**Application by Norfolk Boreas Limited for the Norfolk Boreas Offshore Windfarm.  
Response to the applicants clarification note on trenchless crossings.**

Your Ref: EN010087  
Date: 25 February 2020

**Application by Norfolk Boreas Limited for the Norfolk Boreas Offshore Windfarm.  
Response to the applicants clarification note on trenchless crossings.**

DRAWING No. TP-PB5640-DR023
REVISION F1.0

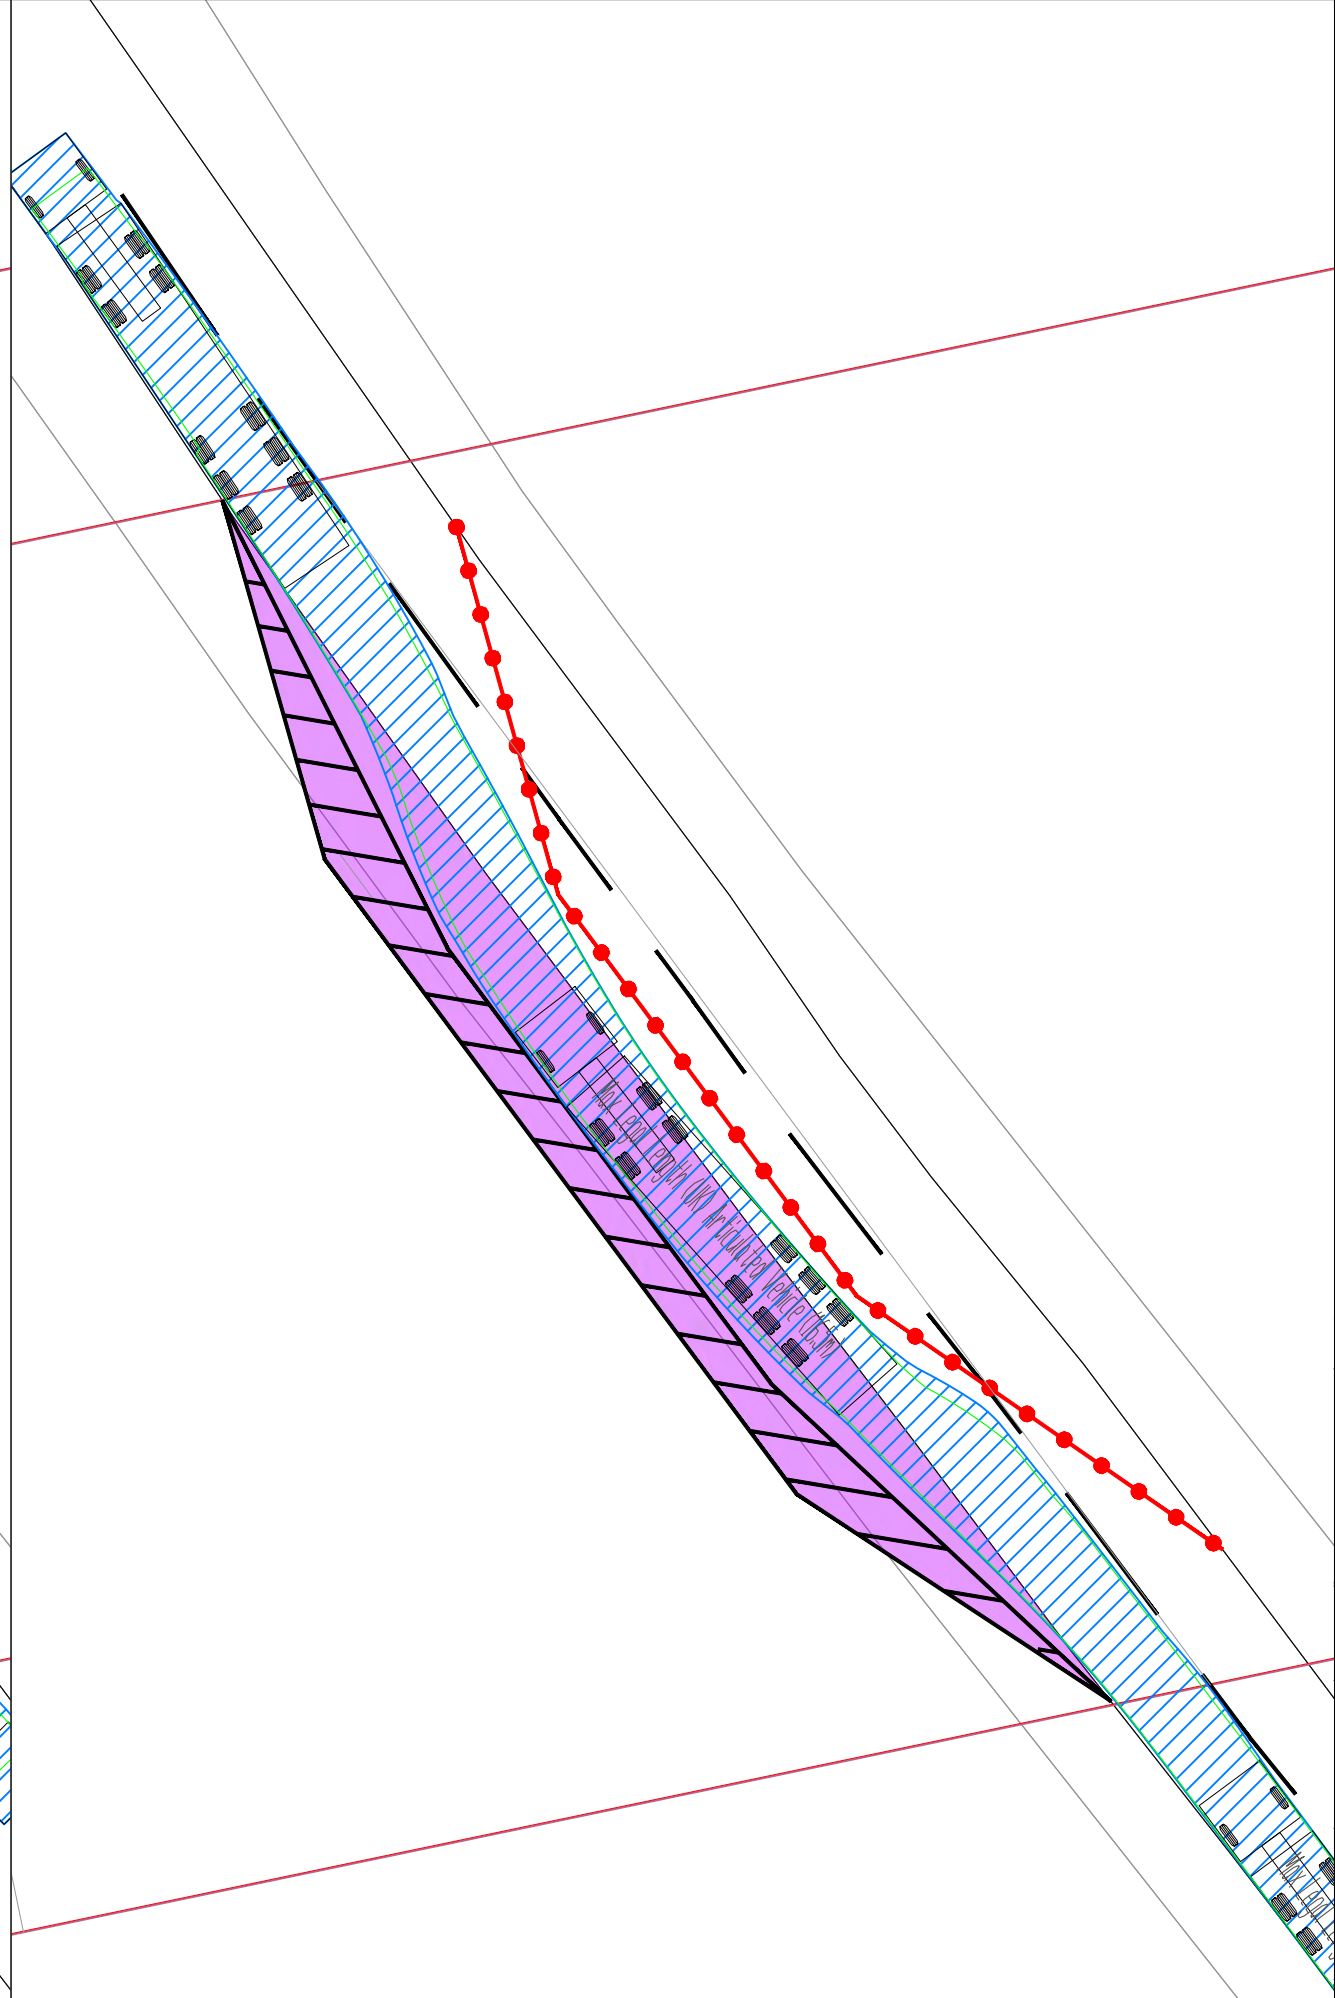
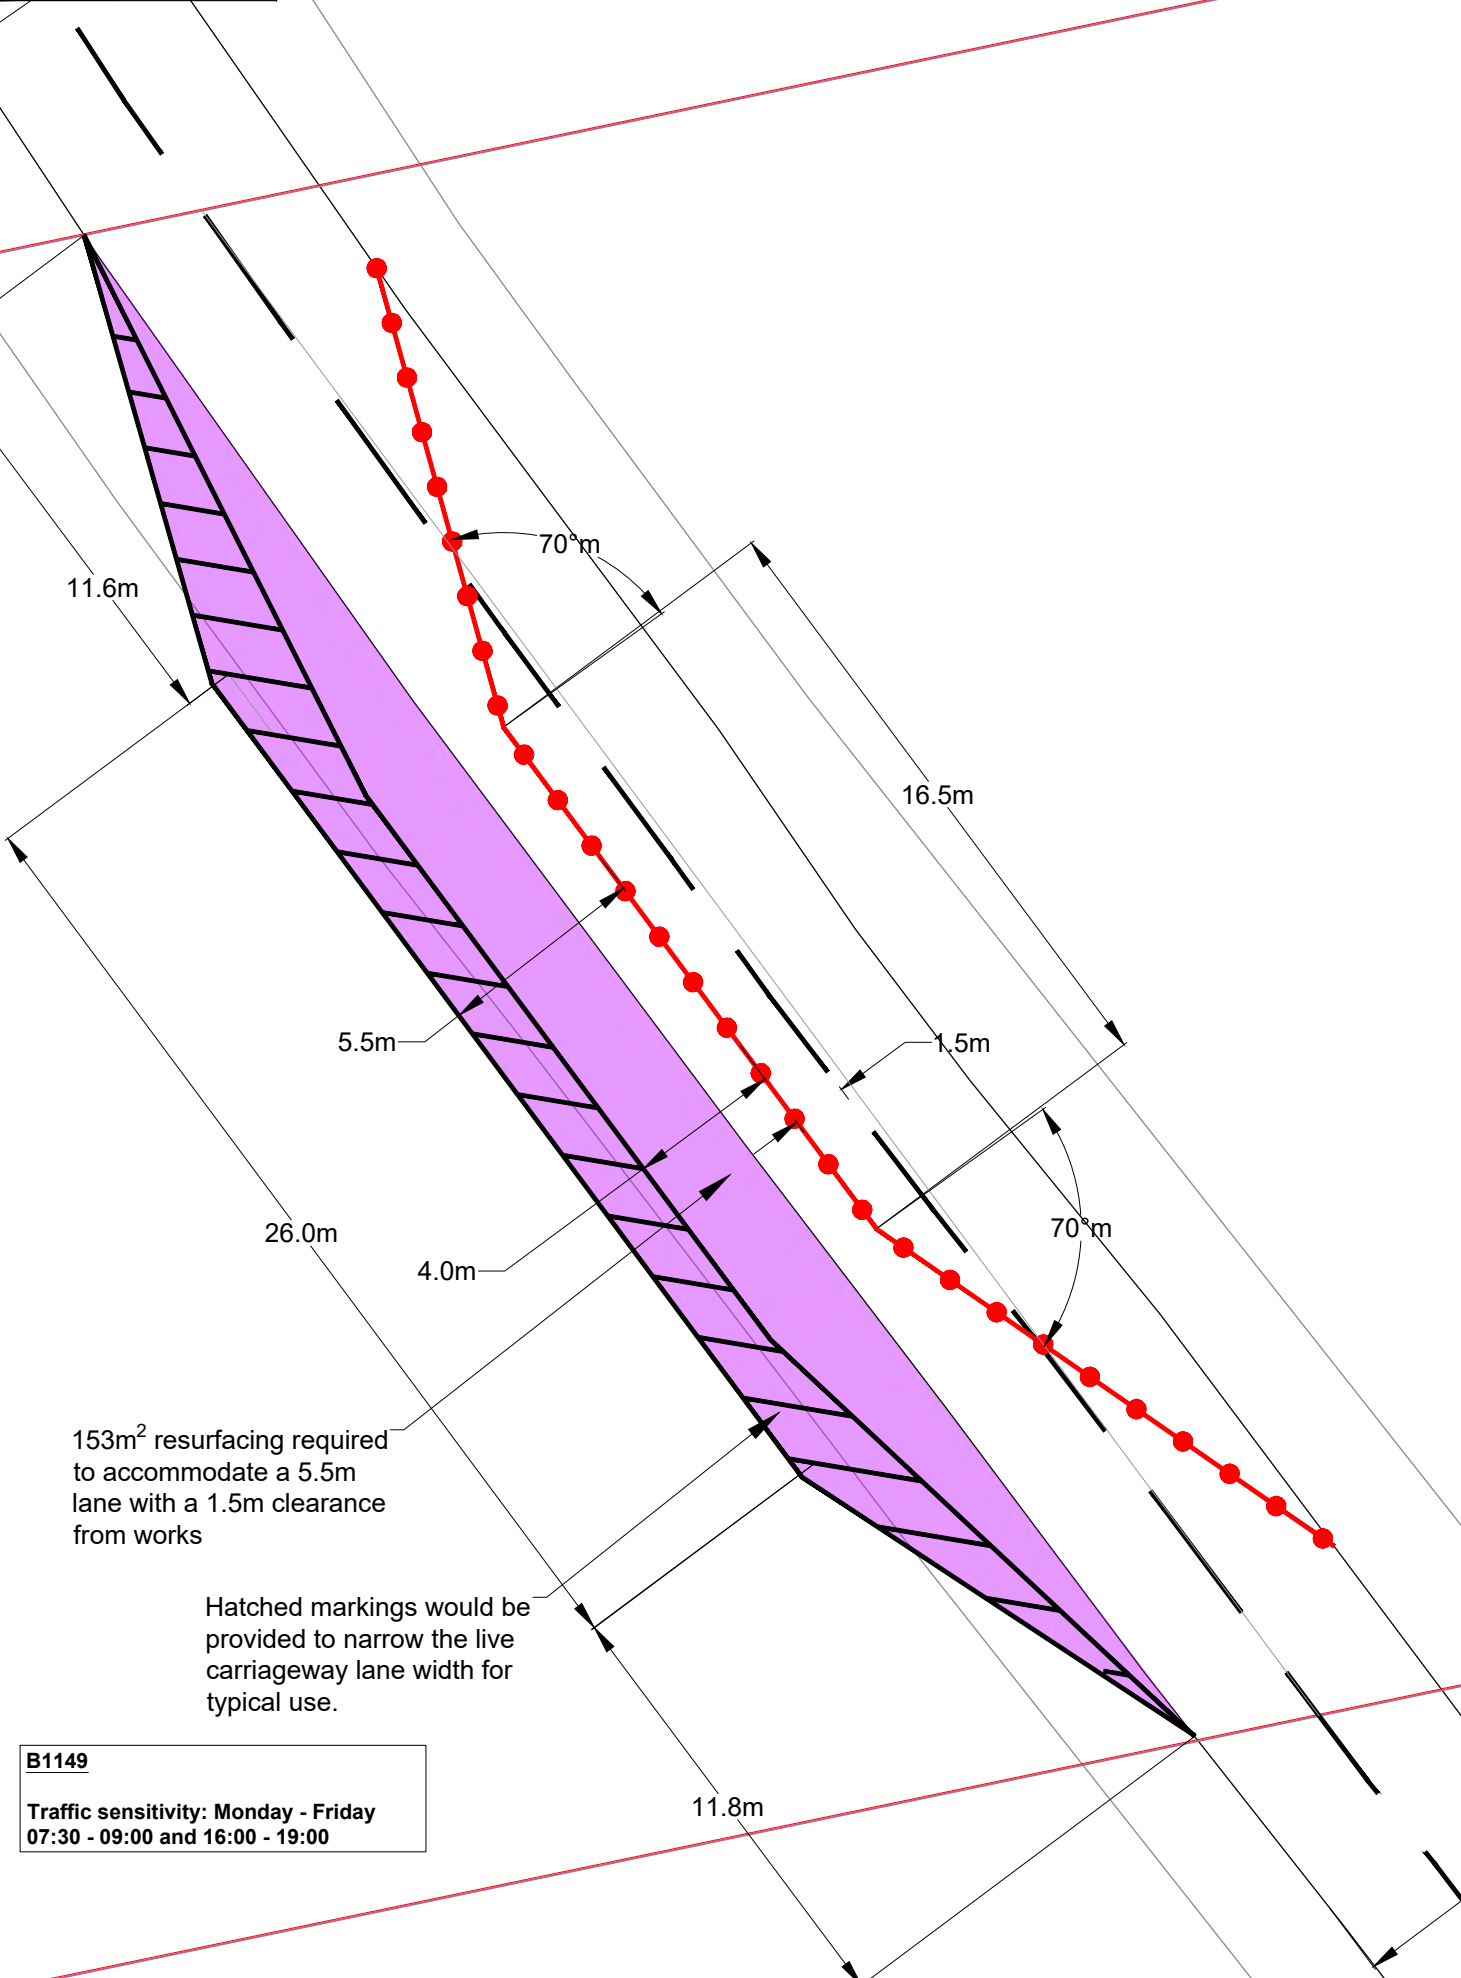
This specific proposal requires the construction of a new diversion lane as shaded pink on drawing numbers TP-PB4476-DR033 and TP-PB4476-DR036 attached to the applicants trenchless crossing clarification note. The disruption to road users for this specific proposal will be significant and last for weeks (see also our detailed comments under the heading timescale below).

Open cut trenching for this specific proposal to the B1149 will not only require the road to be dug up but also requires the highway verges and adjacent hedges (together with any trees) to be dug up and removed to accommodate a diversion lane (see area shaded pink on drawing numbers TP-PB4476-DR033 and TP-PB4476-DR036 attached to the applicants clarification note).

- Requires the highway verges and adjacent hedges and part of the field to be dug up and removed to accommodate a diversion lane. (see area shaded pink on drawing numbers TP-PB4476-DR033 and TP-PB4476-DR036 attached to the applicants clarification note).
- Importing new raw materials to construct the diversion lane.
- Importation of granular back-fill for the deep excavation.
- The Outline Traffic Management Plan clearly indicates at para 45 that open cut trenching **would require a running track** to deliver equipment to the installation site from mobilisation areas and will require separate storage areas for topsoil and subsoil.
